## Hearing Transcript

<b>Project:</b>	One Earth Solar Farm
<b>Hearing:</b>	Issue Specific Hearing 1 (ISH1) - Part 4
<b>Date:</b>	10 July 2025

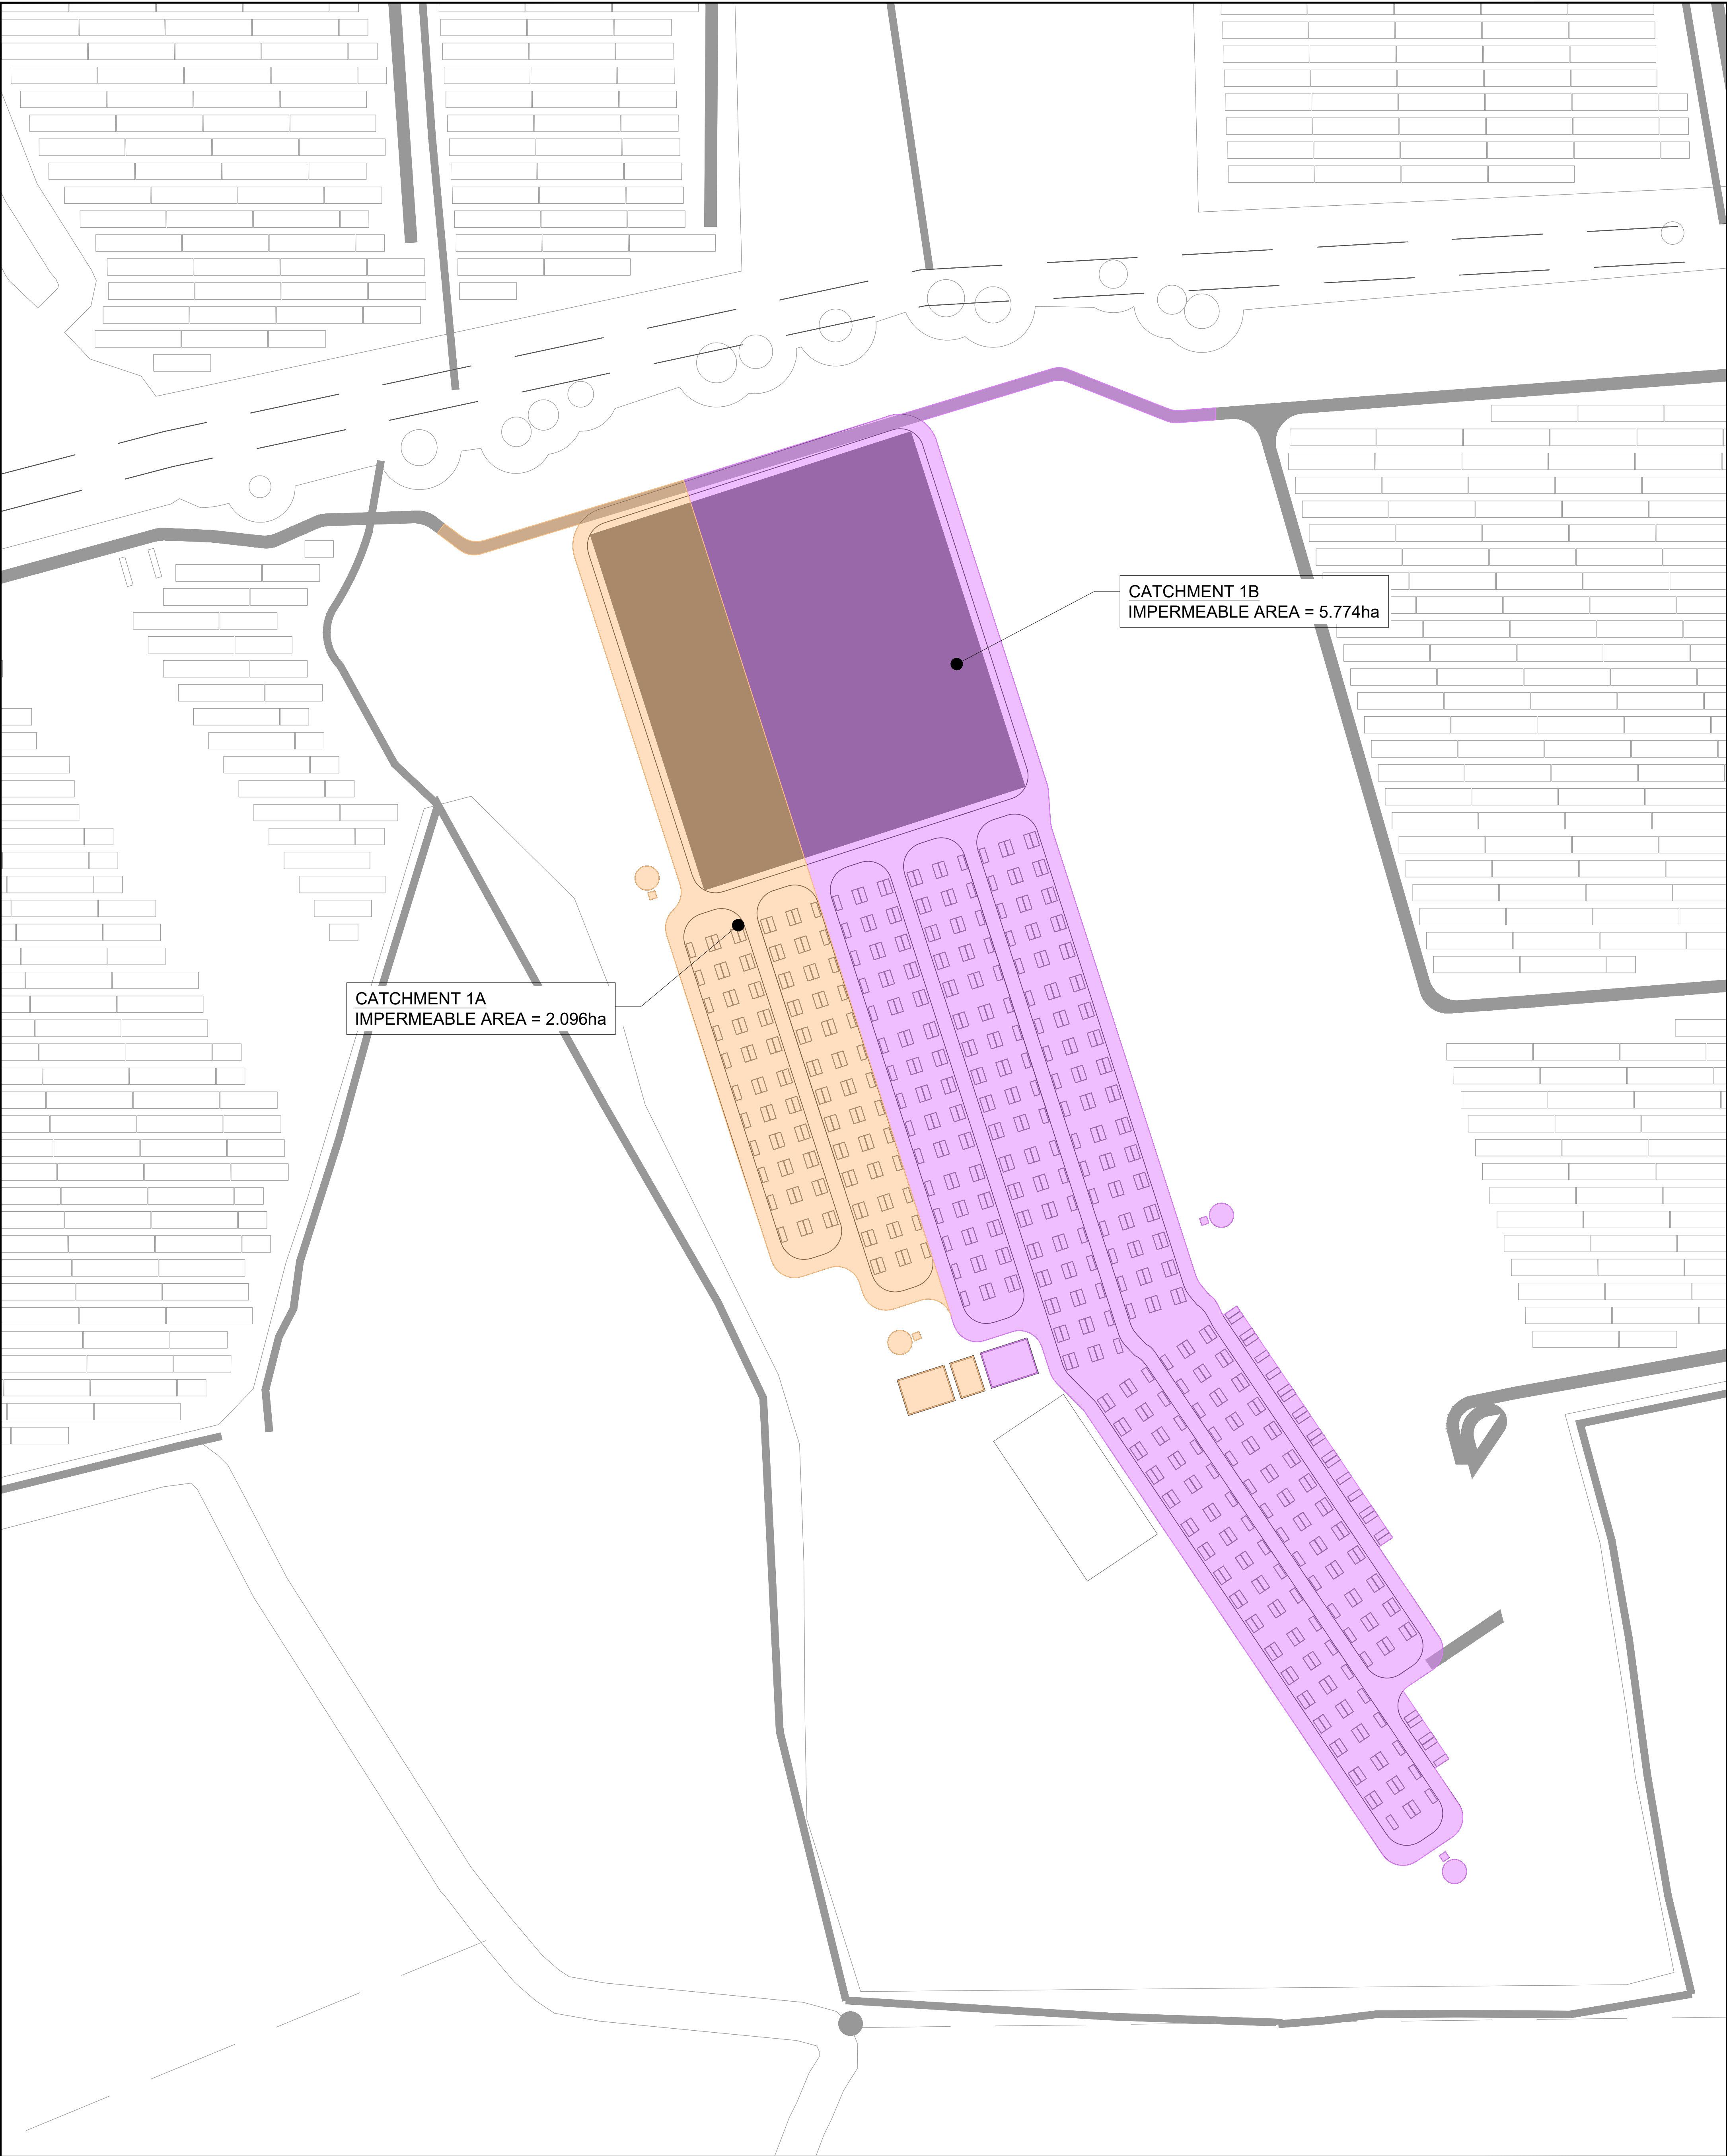
I think I only have one final question on the drainage element. It has to do with the Western, uh, Bess, which you set out, uh, some detail on within the, uh, flood risk assessment and drainage strategy, which is as 051. Um, I if I've understood it correctly, you're going to do a cut and fill for the best to, uh, change the level to ensure that it is, uh, a minimum of 300mm above the predicted flood level.

is the intention to raise the level on of the Western best so that the, the whole structure is actually going to be elevated relative to current ground levels? I appreciate if it's a cut and Phil, it'll be higher at one end and lower at the other subject to current ground levels. But is that a correct understanding because it it.

Within figure 318 and then um, seems to be reference to a nine metre minimum height, which would potentially be an increase in certain areas of 2.78m. I'm just wondering if I'm understanding that correctly.

You're ending up with a flat site on which all of the equipment would sit. So what height is that going to be at?

An illustrative plan showing us what, uh, is likely to be, uh, the, uh, design. I appreciate it won't be final, but I think that might be actually helpful for us to understand how it would work relative to current ground levels, because particularly if it's not going to be a single, uh, flat site, but it's potentially going to be tiered or stepped in some way. again. I don't think there was any understanding, certainly from my point, that that was one of the possibilities.

Be like an elevation drawing showing the existing ground, the made ground and the, the heights relative to a cart through the middle of the.

A section through and an elevation. And again, I appreciate it won't be a final, um, thing because the design is yet to be concluded, but just to get a, an understanding of extent, the extent of what's likely to occur. And then obviously that can link back to what the ES has assessed in terms of heights and so on, so that we can get clarity on that particular aspect, both in terms of the the water environment, but also the landscape environment.

That Craig Thwaites, on behalf of the applicant. Um, yes. There is reference to um, a slight sort of cut and Phil, um, assessment that would be required. Um, that is on the basis that the Western best could, in theory, um, be within the residual breach flood event. Um, now I think the, the, the, um, any raising

of the, um, sort of battery storage areas to be 300mm above that. Um, it's a very conservative approach to it.

Um, and the it's mentioned within the Fra that that would only be undertaken outside of the flood extent, um, to ensure that there's no impact on floodplain storage. Um, as a result.

Craig Thwaites on behalf of the applicant. So that that 300 mil raising um, would only be um, within areas where the, um, where any best could in theory be within the extent of the potential breach. Um,

Thwaites on behalf of the applicant. Um, I don't believe that we are ending up with a flat, um, uh, site for the best areas. However, if Mr. Sneddon would would like to interject. I'm happy for him to, um, on that. Um, it was for the point that we have made within the Fra is just that where required, um, levels would be raised above sea level, would be raised.
